Simon Truong - RE: Re: FW: Block 4S Queries

From: "Alex Sicari" <Alex.Sicari@frasersproperty.com.au>
To: "Simon Truong" <Simon.Truong@planning.nsw.gov.au>, "Gordon Kirkby" <GKirkby@jbaplanning.com.au>
Date: 4/09/2013 8:54 PM
Subject: RE: Re: FW: Block 4S Queries
CC: "Ben Lusher" <Ben.Lusher@planning.nsw.gov.au>, "Mark Brown" <Mark.Brown@planning.nsw.gov.au>, "Michael Goldrick" <Michael.Goldrick@frasersproperty.com.au>, <rpalmer@fosterandpartners.com>, <EKirkman@jbaplanning.com.au>, <trevorhamilton@nettletontribe.com.au>
Attachments: 130904 - B4S GFA sk117-sk132 (clarification provided to DPI) pt 1.pdf

Subject: Block 4S Queries

4067\_4S\_SK125

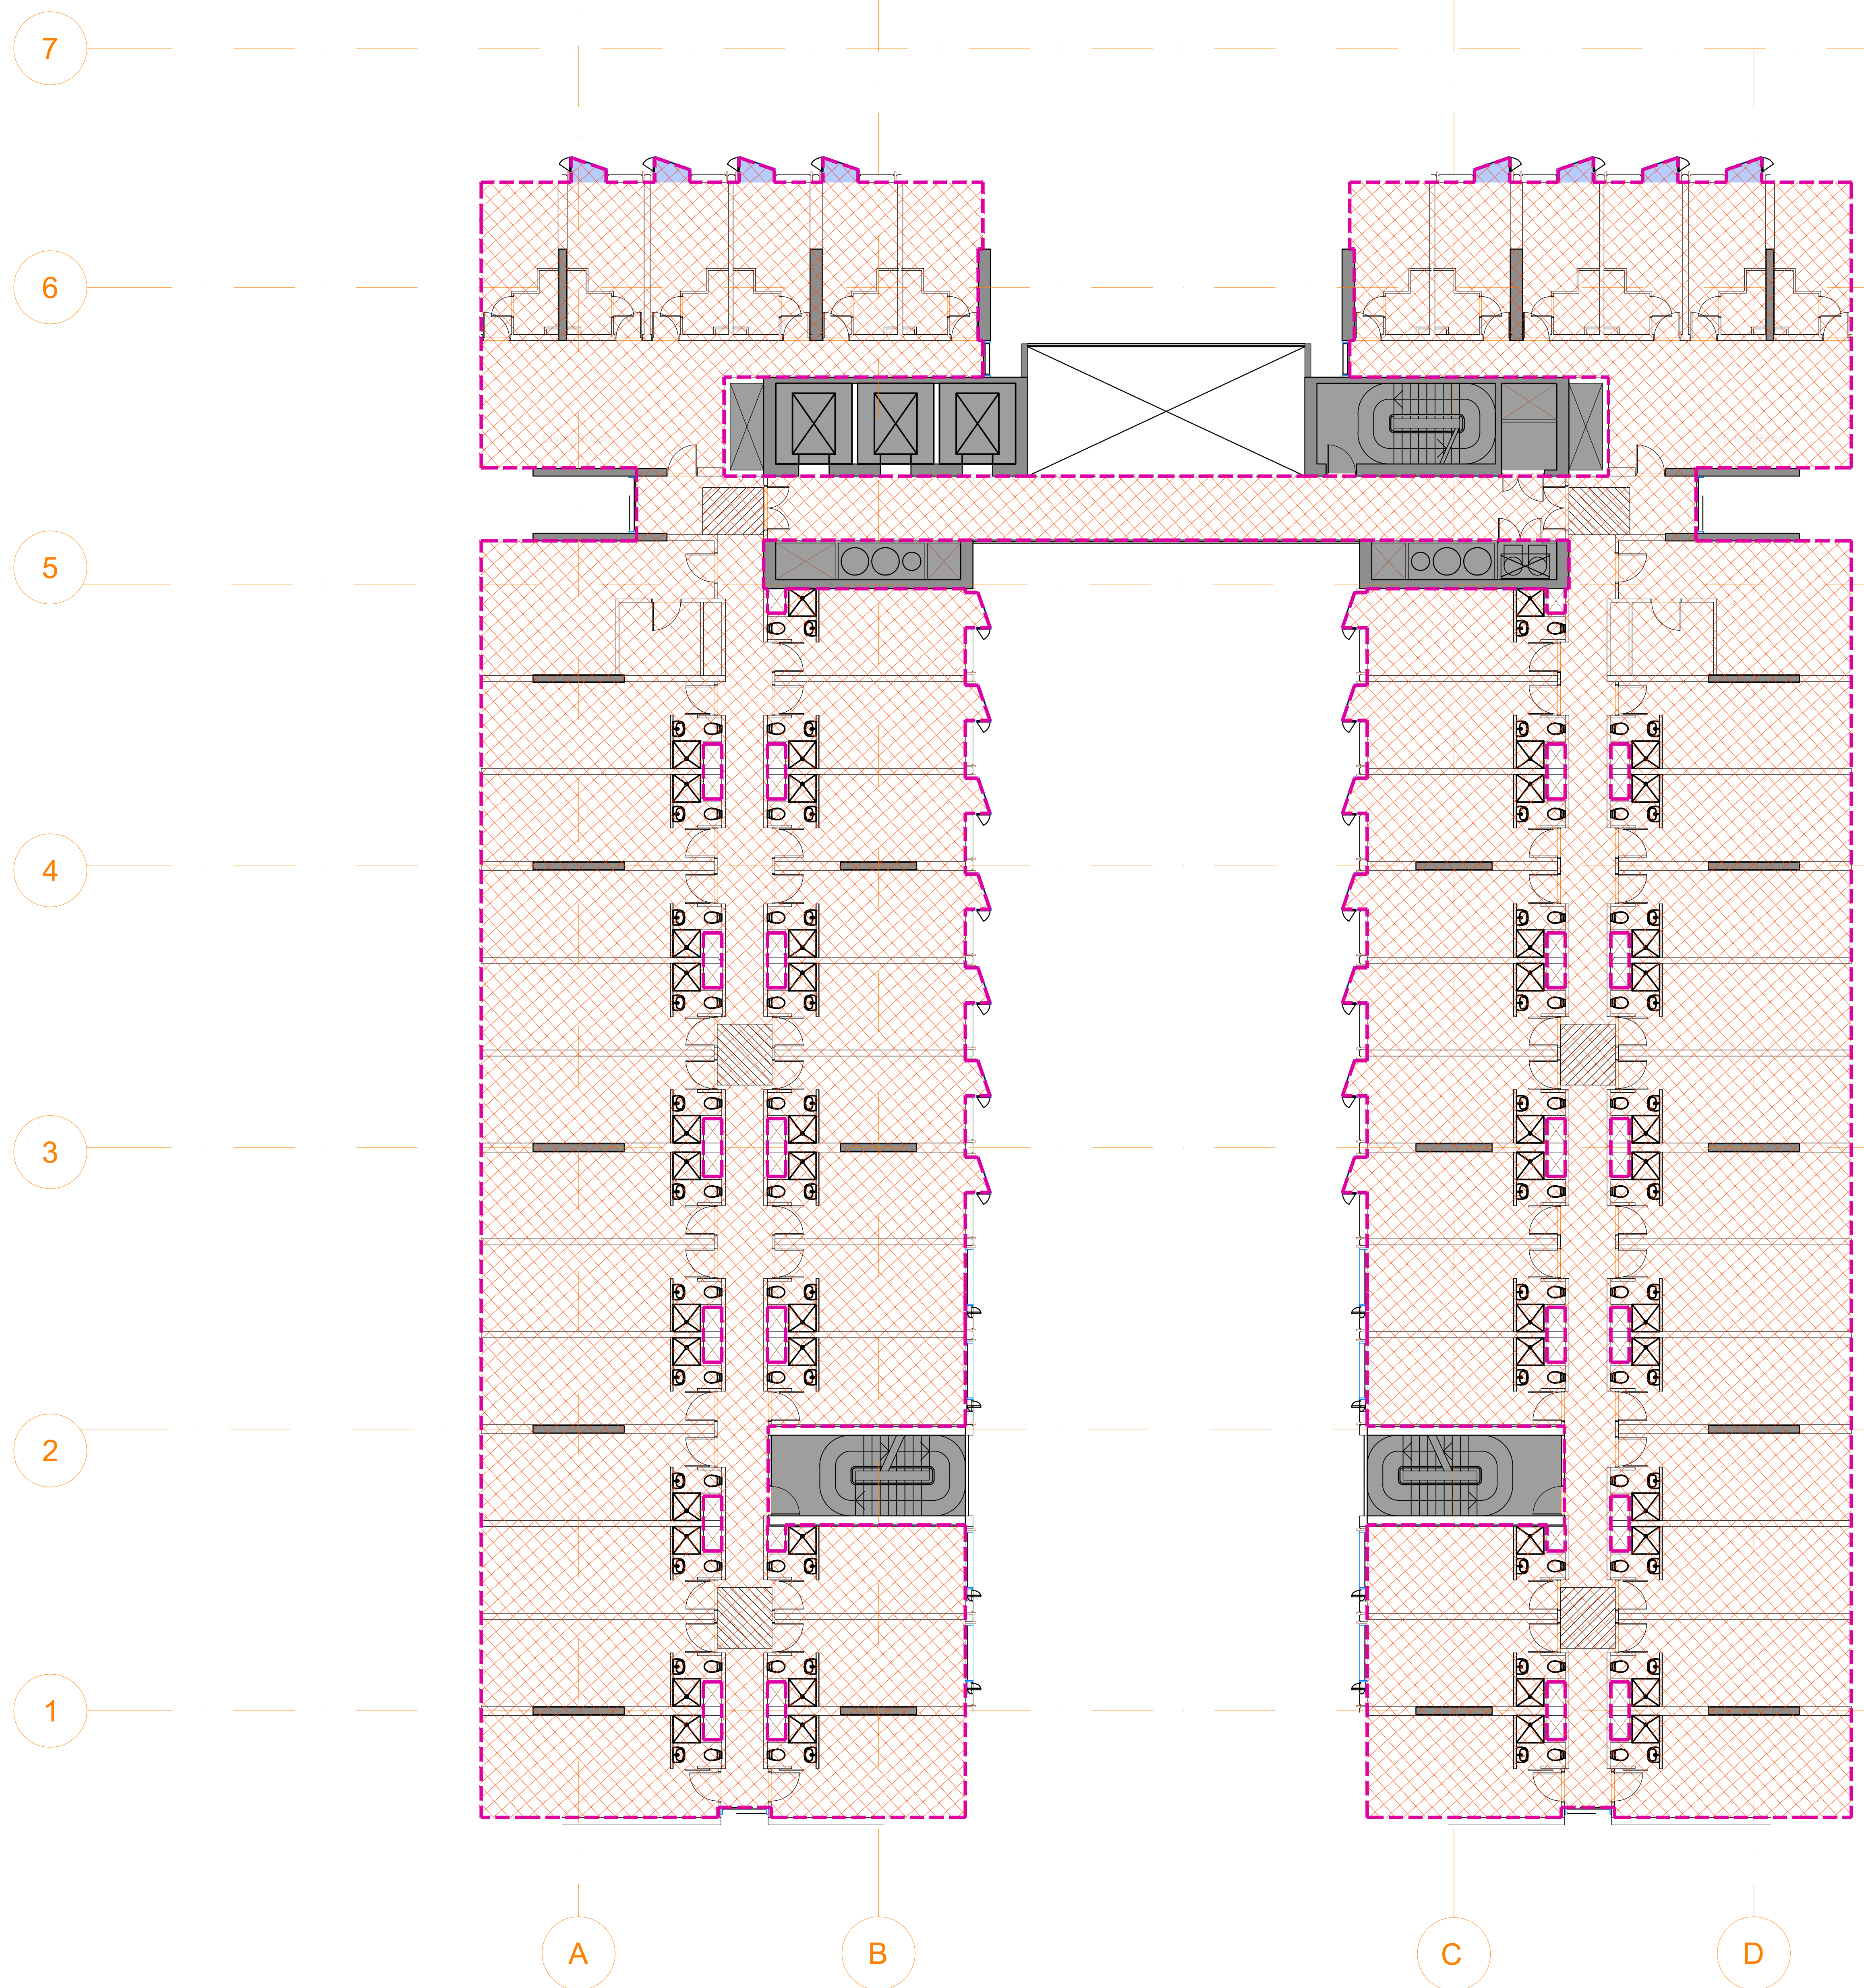
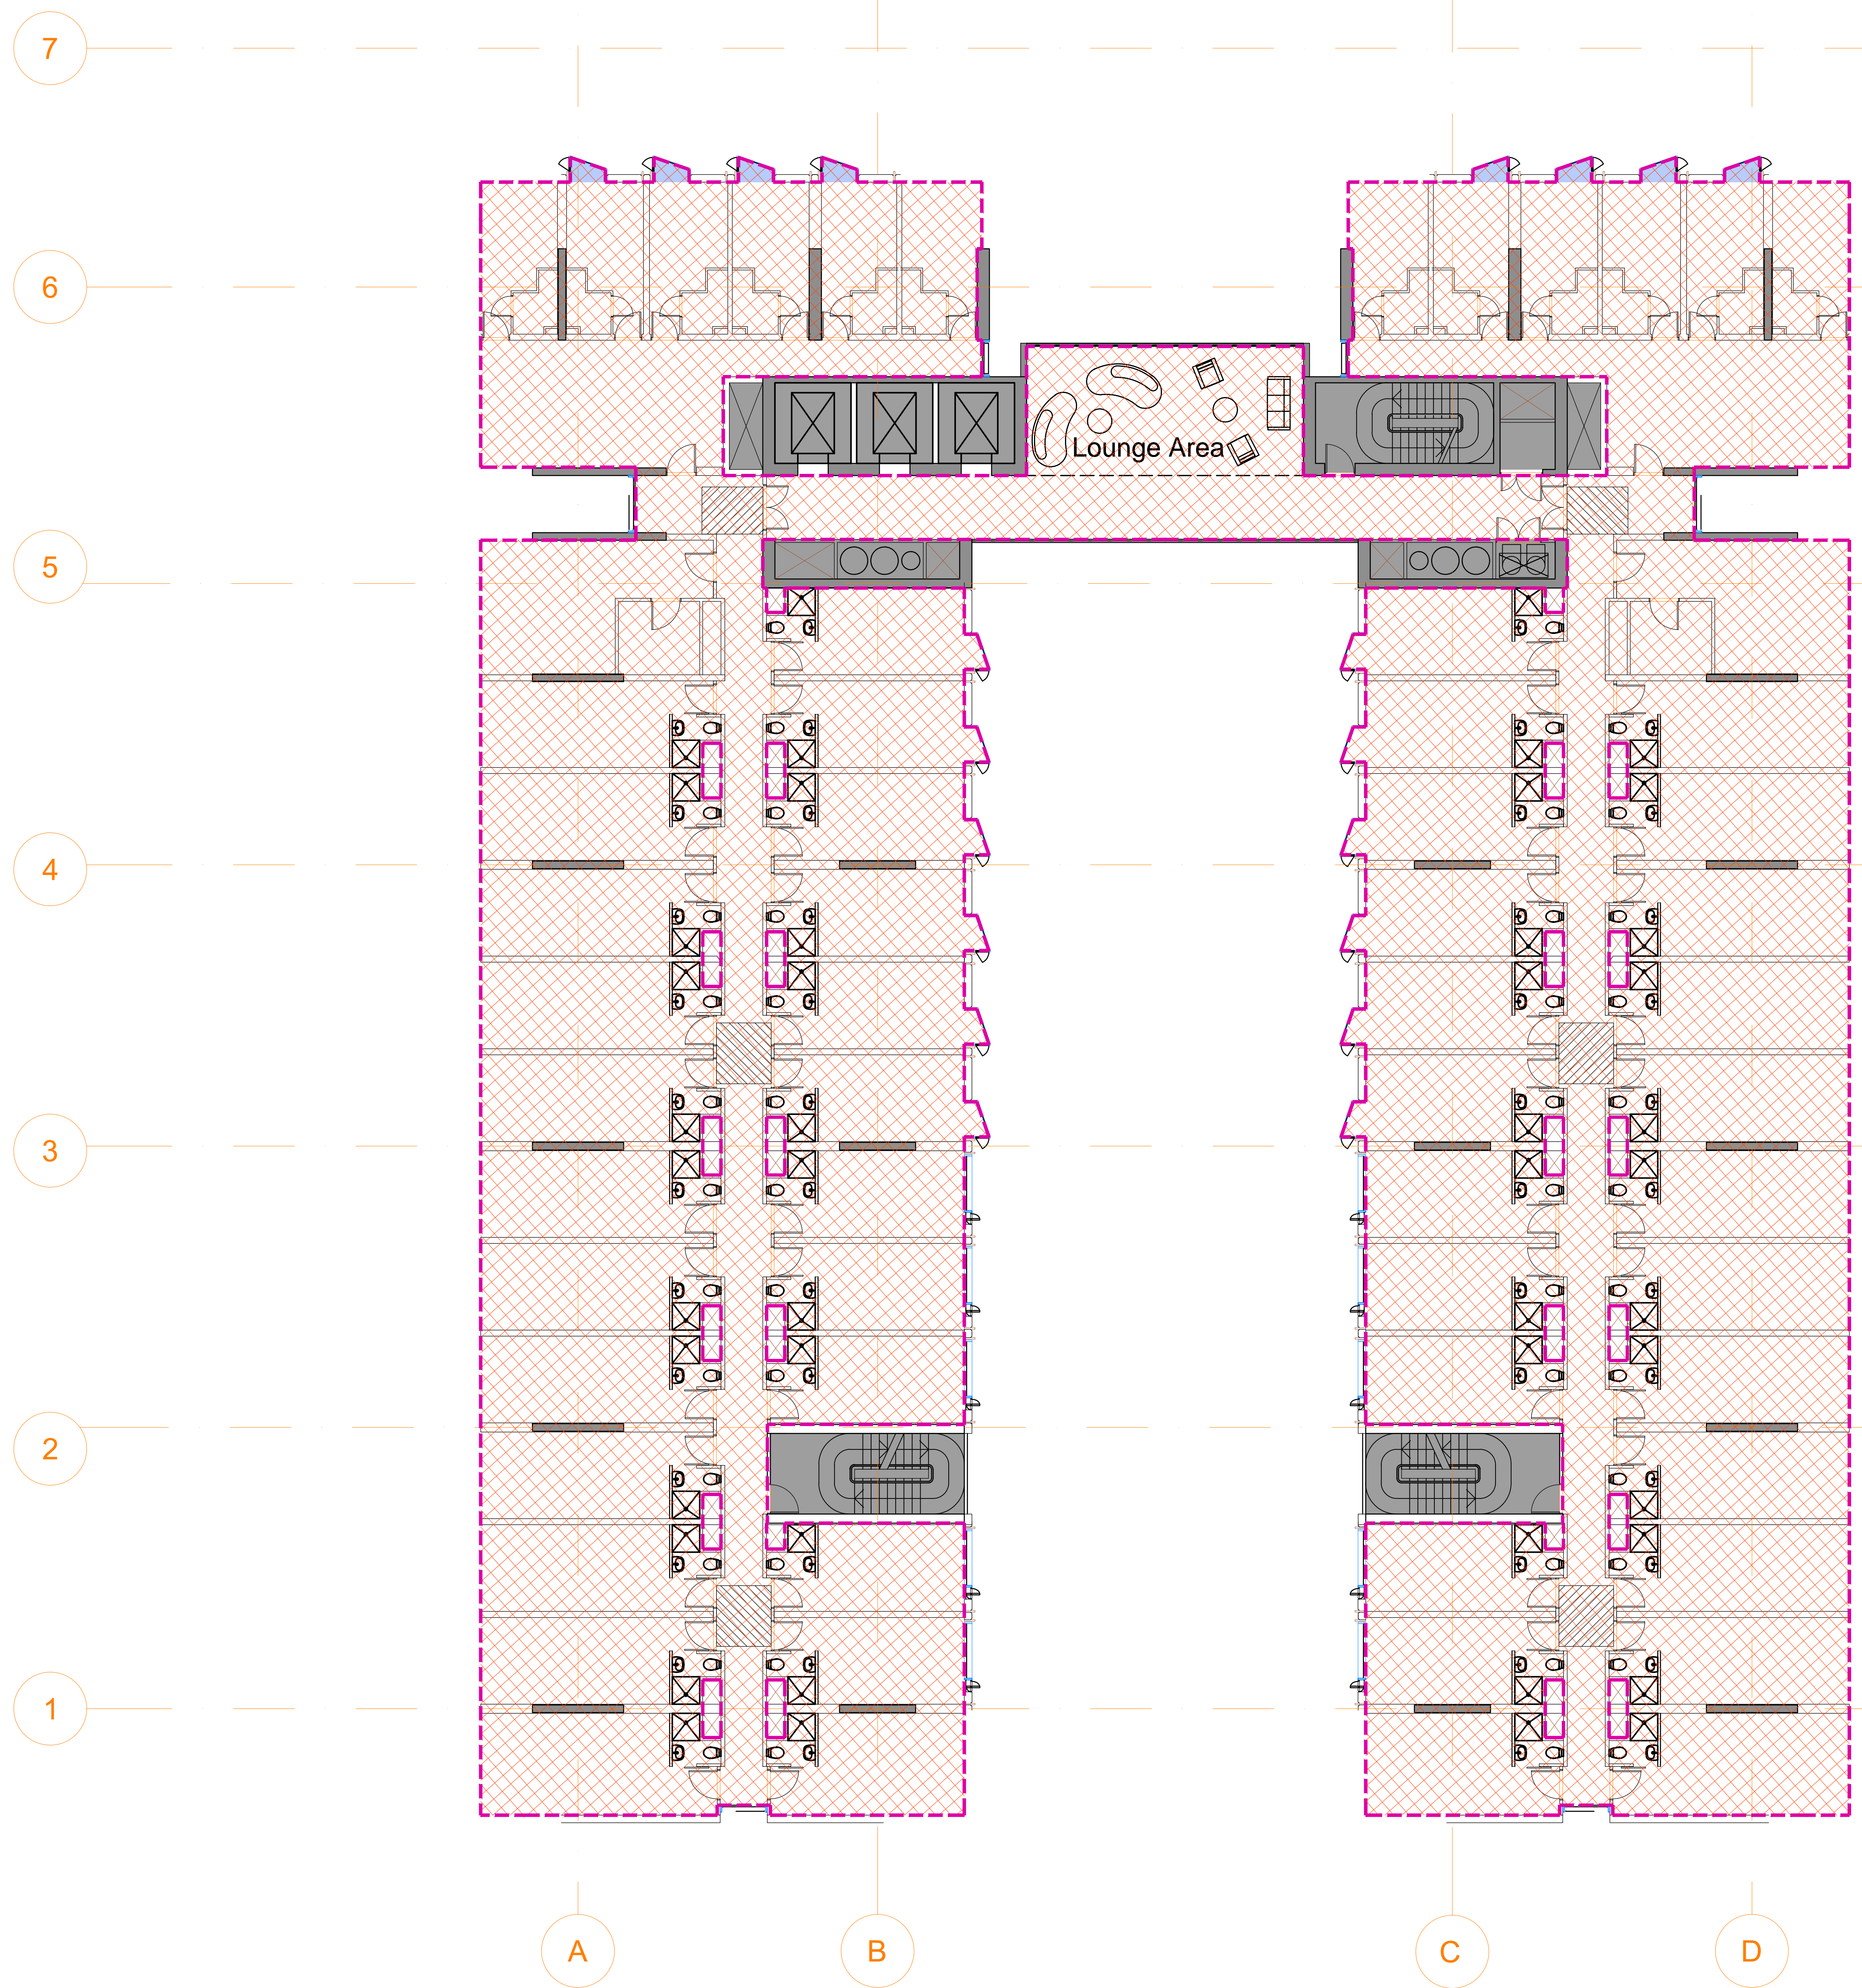
The area schedule on drawing 5013[4] as submitted with the SSDA confuses GFA, NLA, and external area. It does not measure Residential vs Non-Residential GFA.

I note the proposed GFA for Block 4S, however the Department's query relates to the GFA numbers provided.

Can you please clarify?

Modified Concept Plan	Proposal
Residential GFA	23,500m ²	20,991m ²
Non-residential GFA	1,000m ²	901m ²
Total GFA/FSR	24,500m ²	23,813m² (1,921m² unaccounted for)

Residential GFA	22,709.1m2
Non-Residential GFA	1,423.2m2
Total	24,132.3m2

See schedule and GFA-highlighted plans in attachment pt 1 of 2 (due to file size, we will send pt 2 of 2 in a subsequent email)

The difference between the GFA as shown on drawing 5013[4] and the attached is that the bay windows were excluded from the previous measure. We have now corrected this to include for the bay window GFA.
